HINCKLEY NATIONAL RAIL FREIGHT INTERCHANGE

Project reference TR050007

Applicant's Response to Deadline 4 Submissions [part 3 - LCC]

Applicant's Response to LCC Deadline 4 Submission - Comments on any additional submissions received by Deadline 3

Written Statement of Oral Case ISH6 [Appendix C – Plan for A47 link road footway/cycleway design]

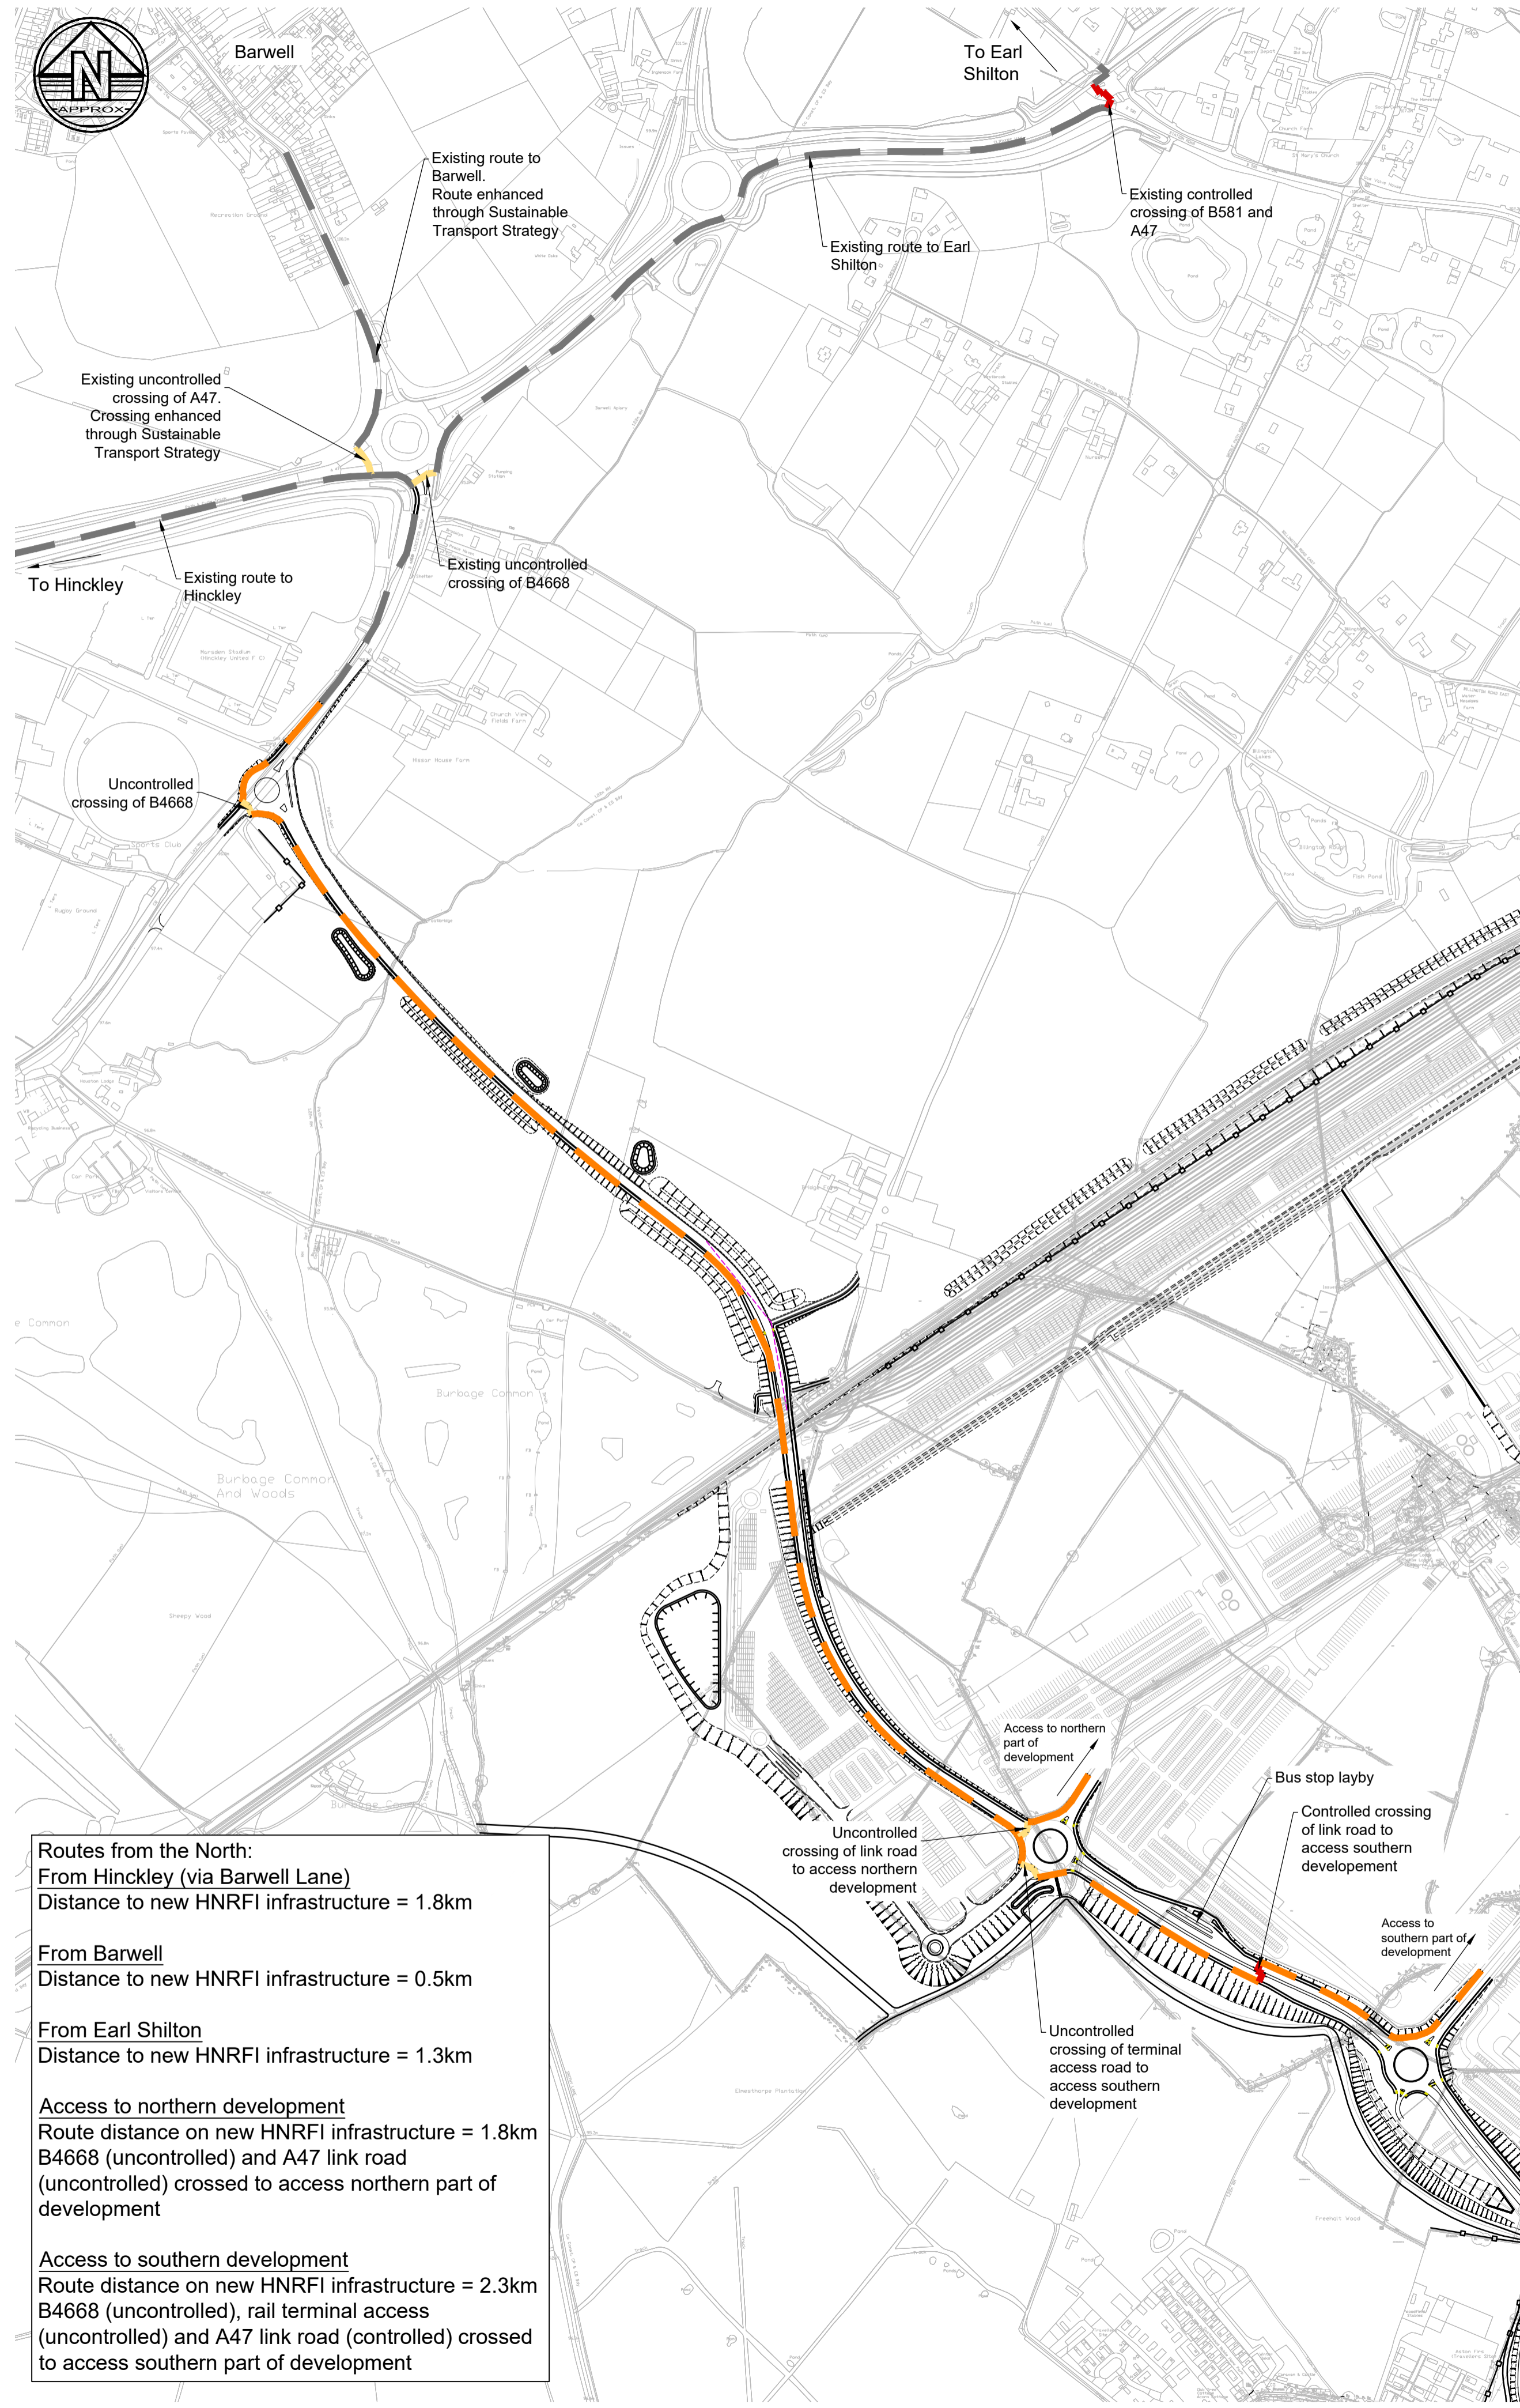
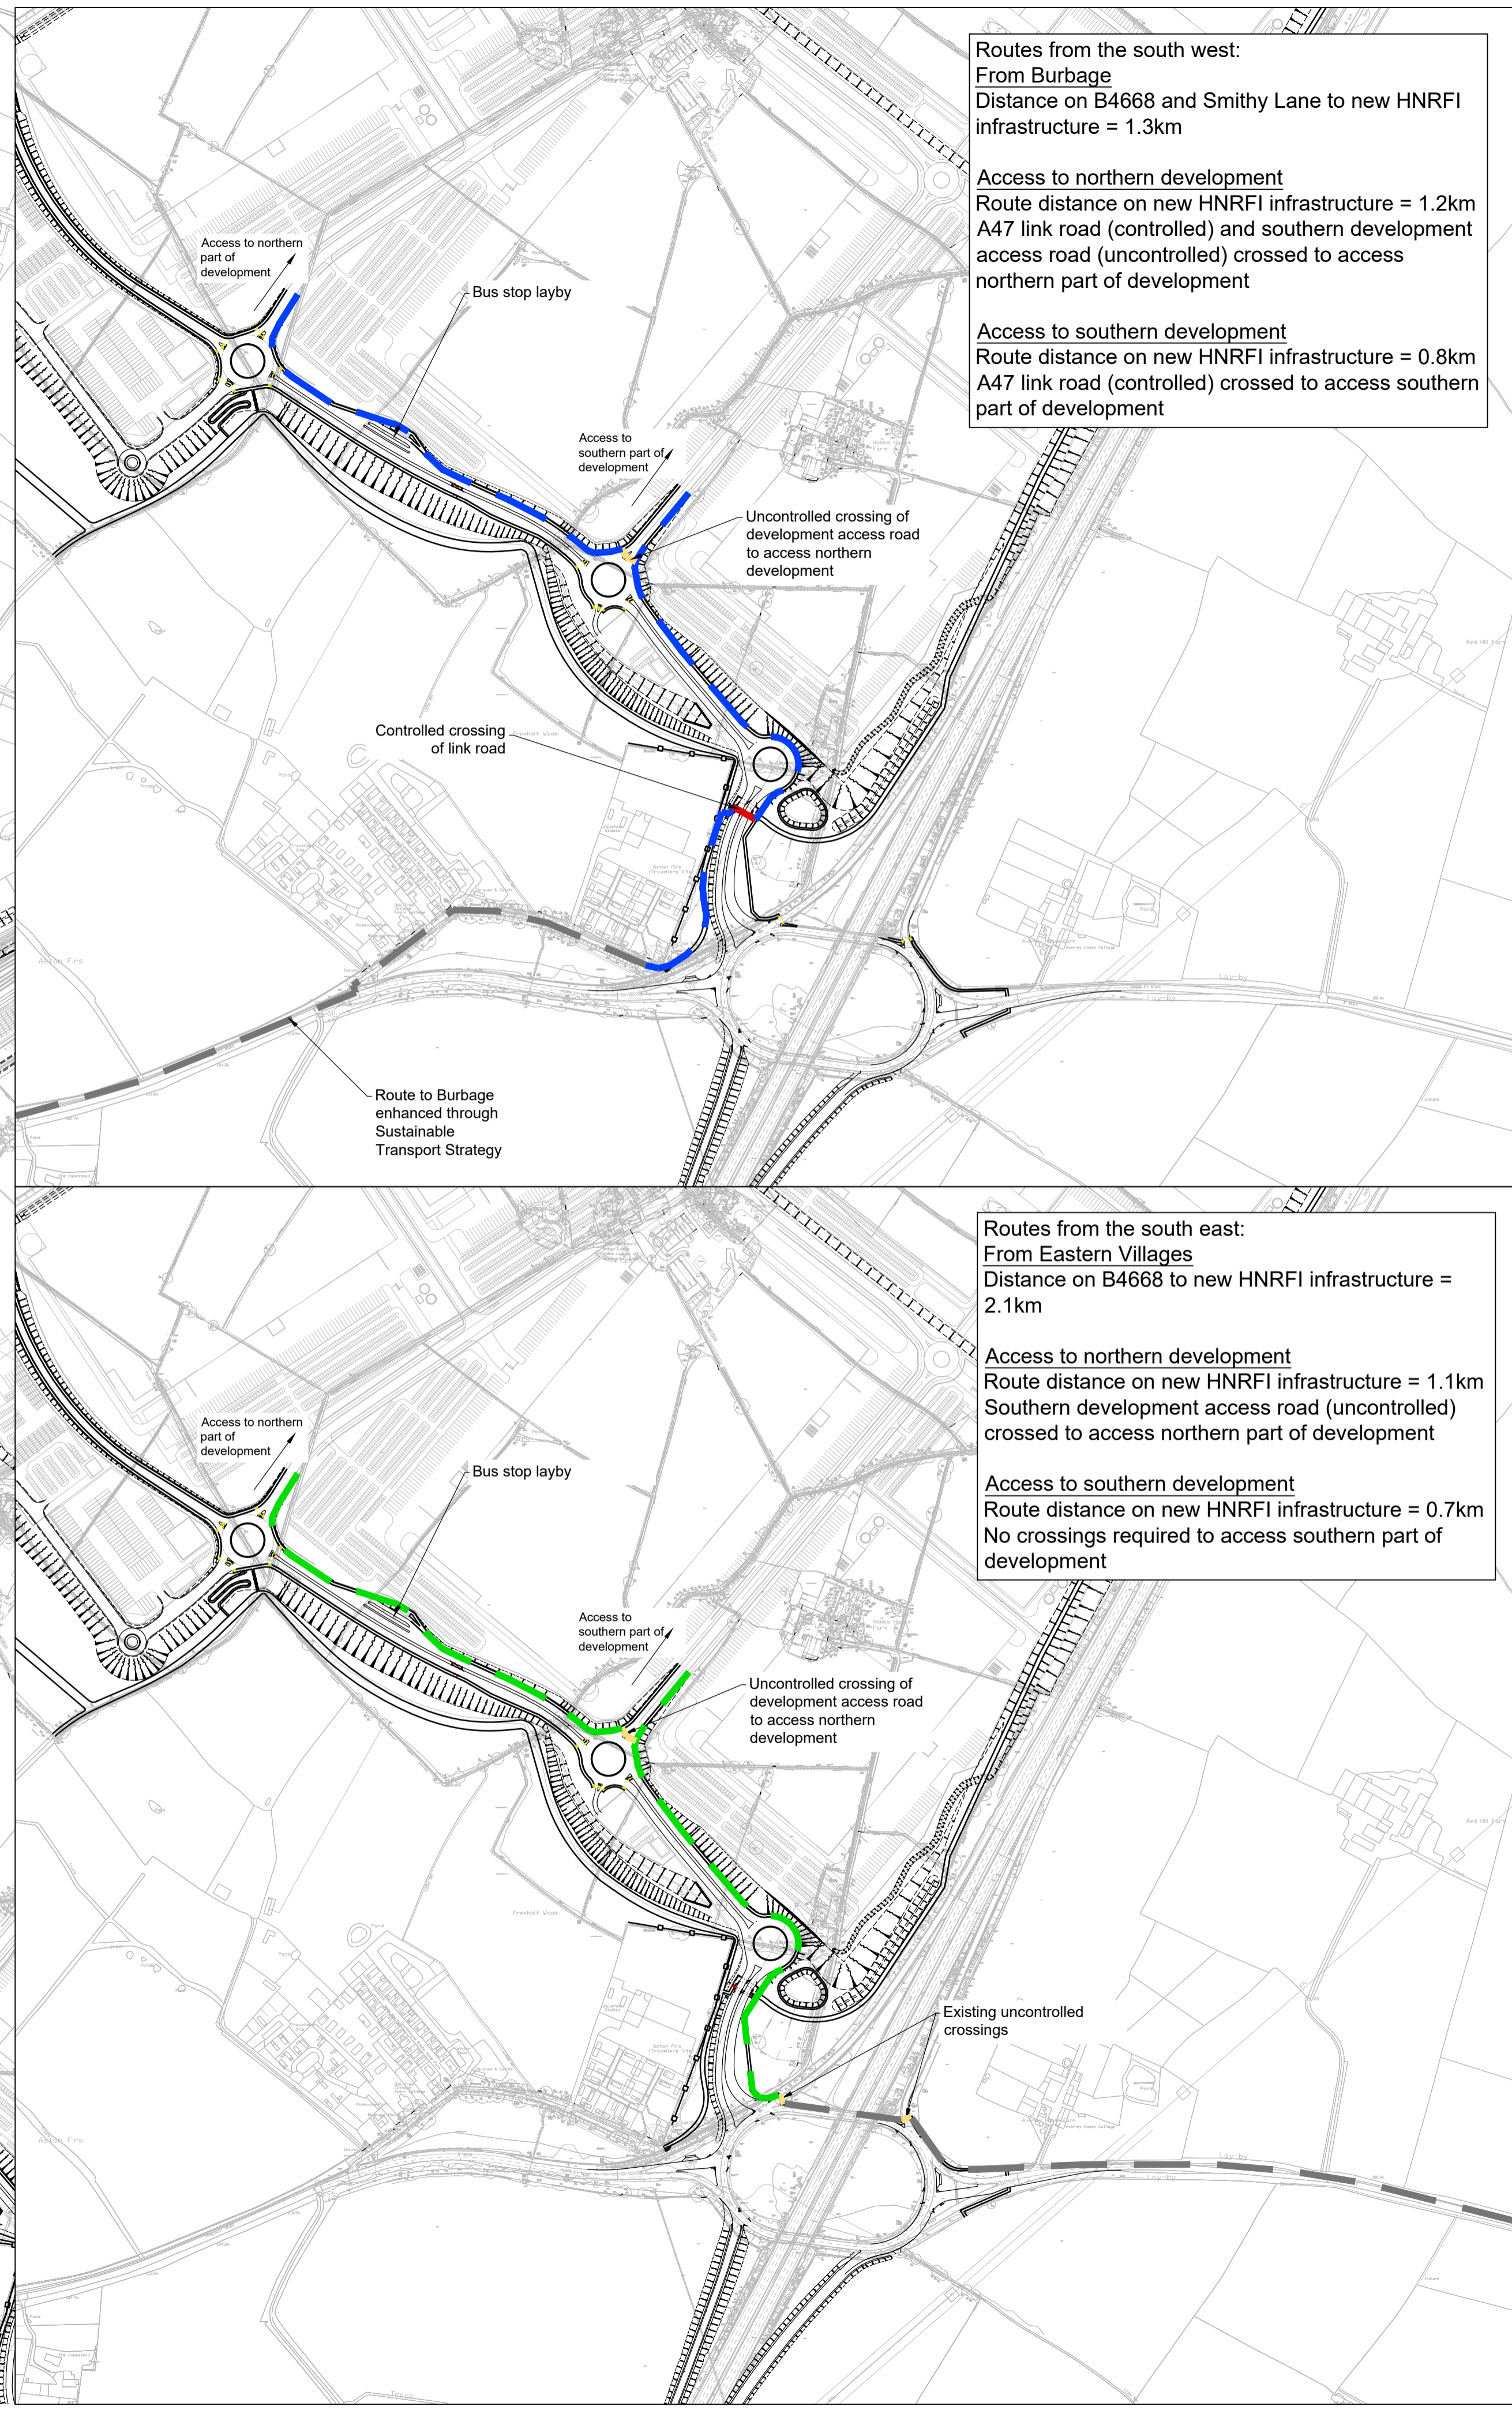
No	ExQ	Question to	Question Response	Applicant's Response
1	REP3-003	2.4A Hinckley NRFI Highway Plan - sheet 1 of 8	This annotated drawing confirms that footway/cycleway provision is only made on one side of the A47 link road (albeit it crosses the link road in various locations). It is unclear why a consistent footway/cycleway is not provided along either both sides of the A47 link road, or indeed consistently on the development side of the road.	The presence of a segregated left turn lane (SLTL) at the B4668/link road junction and the restrictions in CD116 para 8.6 to provision of crossings on SLTL mean that the footway/cycleway connection from the link road to the B4668 is best made from the west of the link road to the existing footway/cycleway on the north side of the B4668. Existing footway/cycleway links to Hinckley and Barwell are accessed from the northern side of the B4668 and the new facilities on the link road connect to those existing using a crossing point on the B4668 at the most convenient and least heavily trafficked arm of the new roundabout. From the junction with the B4668 travelling south, there is an uninterrupted length of 1.5km of footway/cycleway along the new link road which does not require users to cross any roads or private means of access. Once the 'urban' section of the link road is reached around the development, there are crossing points provided (both controlled

No	ExQ	Question to	Question Response	Applicant's Response
				<p>and uncontrolled) to access the development. The design proposed does not provide a footway/cycleway along both sides of the link road north of the railway due to the rural nature of the link and the lack of desire line for users on the eastern side given the point above regarding access to the B4668. There are several examples of similar rural sections of link road providing footway/cycleway facilities on a single side such as the A47 near Earl Shilton and the Kegworth bypass provided as part of the East Midlands Gateway development. Footway/cycleway facilities are provided along both sides of the link road for the majority of the 'urban' section south of the railway. The Applicant considers that the routes provided cater appropriately for people using the link road to travel between likely origins and the development site with long lengths of uninterrupted, good quality footway/cycleway and appropriate crossing points provided where required. A plan illustrating the key routes to the development via the link road is appended to this document (document reference 18.15.3)</p>
